CITY OF PORTLAND

RE: 131 Sherman St.-First floor

Your application to make a change of use from apartment to neighborhood municipal center, has been reviewed and a permit is herewith issued subject to the following requirements:

131 SHERMAN ST.  
1st Floor

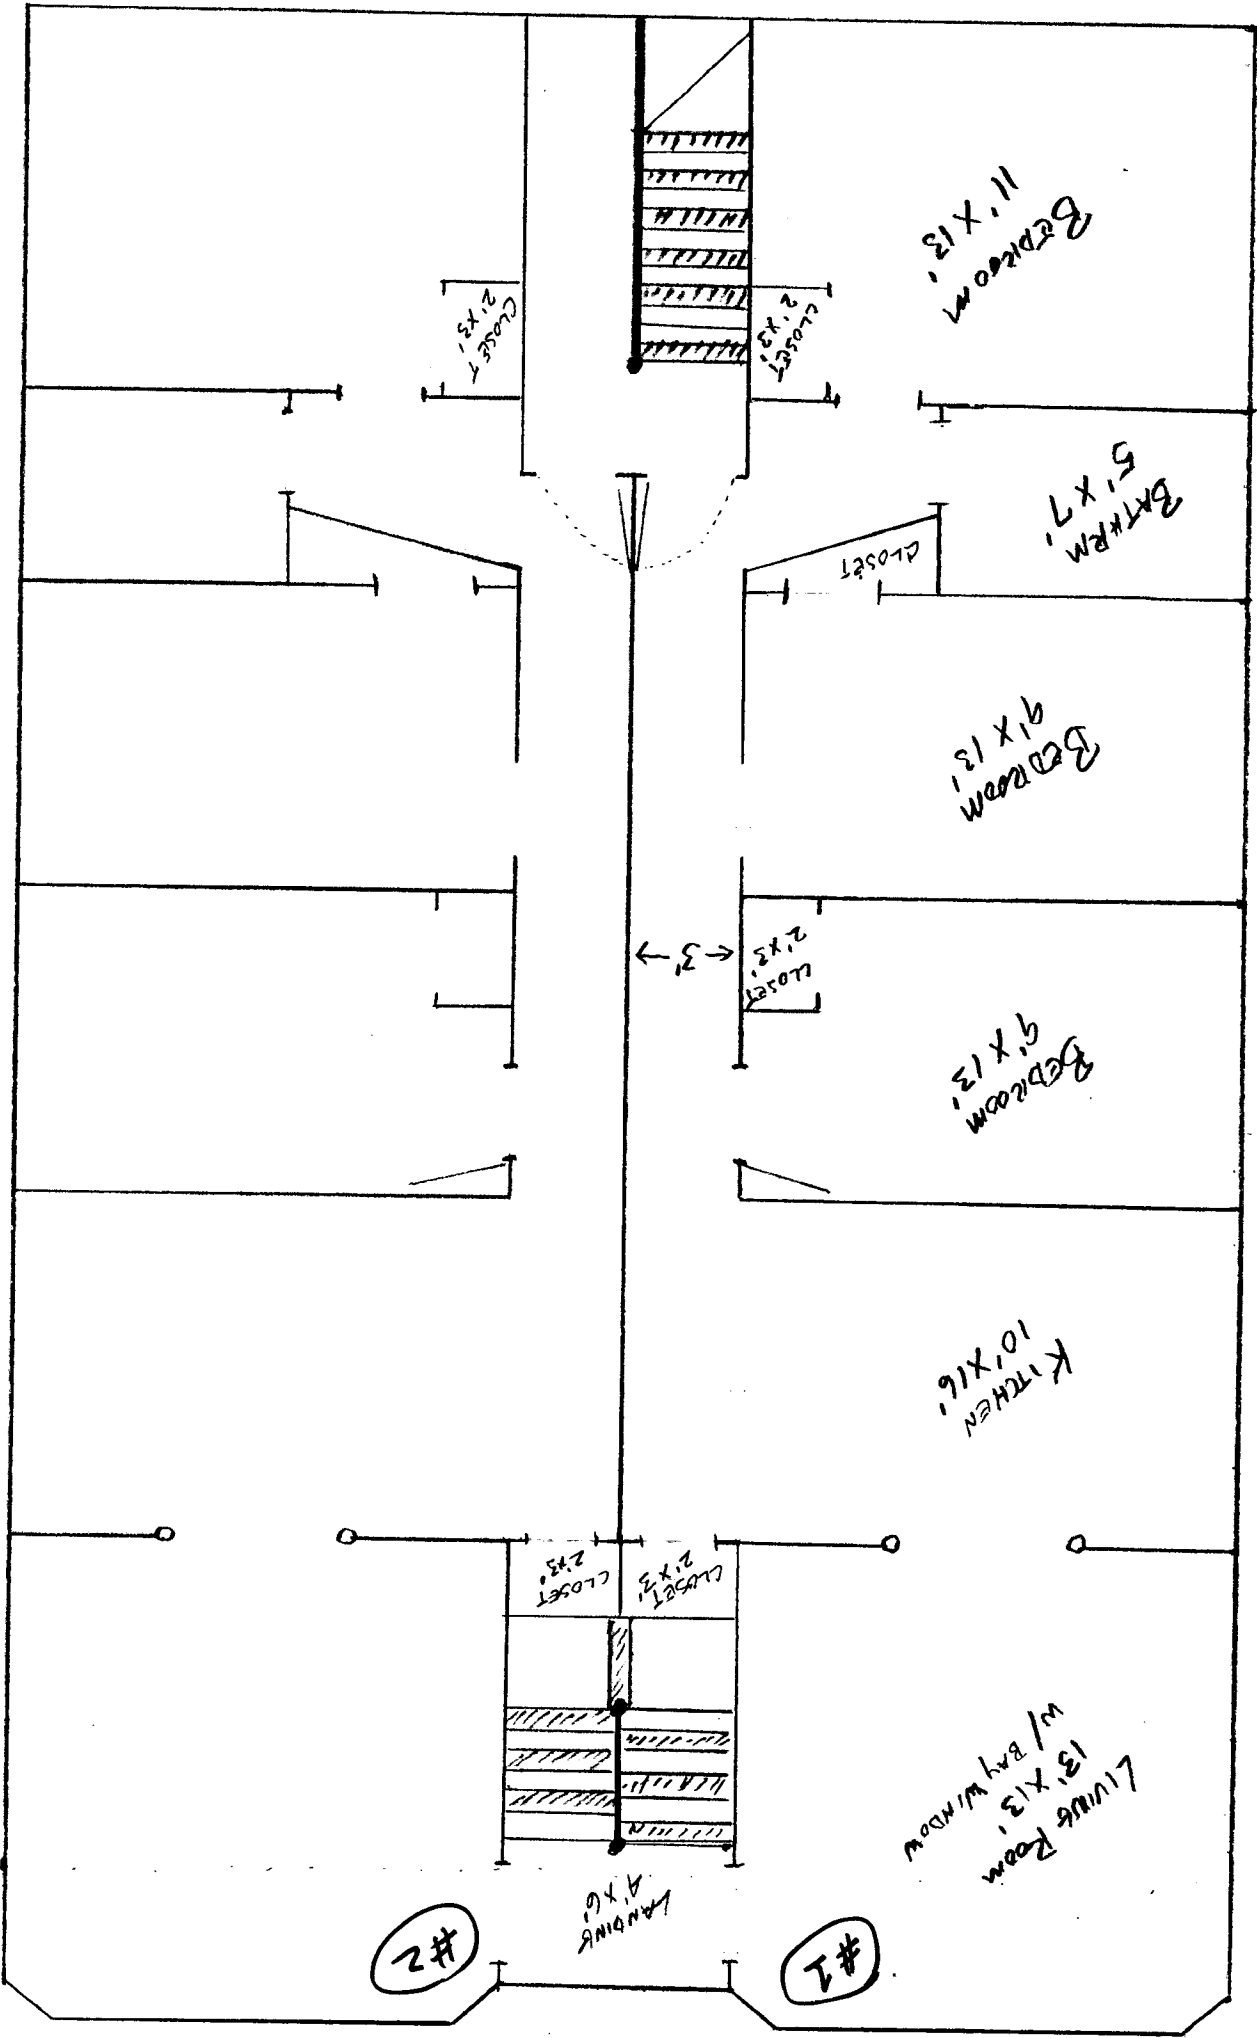
1. Portable fire extinguishers shall be provided as per NFPA #10.
2. All exit signs, lights and means of egress lighting shall be done in accordance with Article 8 section and subsections 822.0 & 823.0 of the city's building code. (The BOCA National Building Code/1990)
